**Consultation Response from KC,
Conservation & Design**

2025/91531 land off, Leeds Road, Heckmondwike, WF16 9DB

Demolition of existing semi-detached houses and associated buildings, and construction of 51 dwellings, including associated access and other associated works

Date Responded: 17/12/25 & 15/7/26

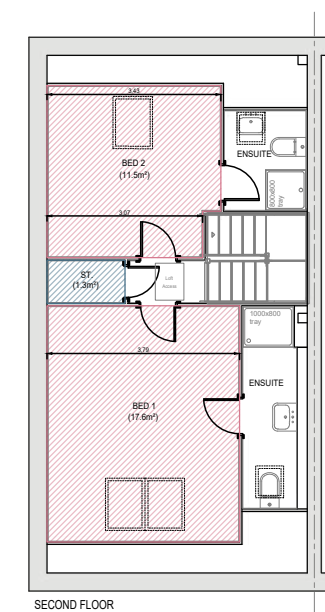
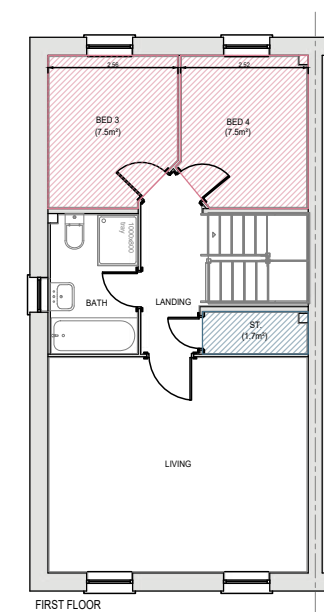
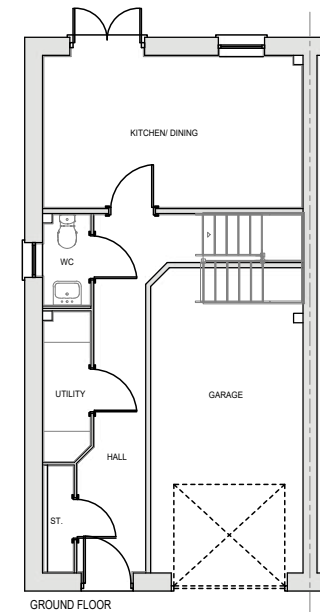
The use of some local coursed natural stone is encouraged on the dwellings at Plots 30-36 within the vicinity of the listed building and possibly Plots 37-39. The use of natural slate roofs is also encouraged for these plots. The use of natural materials would be more appropriate within the setting of the listed buildings and for the development to fit in with the local distinctiveness of the wider area which includes the use of some natural stone and mainly natural slate.

Hedge and dry stone walling along the access track boundary should be encouraged and would be better than just fencing to provide an appropriate setting to the approach to the listed building.

A landscape buffer using native tree and hedge planting should be encouraged and would be appropriate to the setting of the listed building and perimeter of the site.
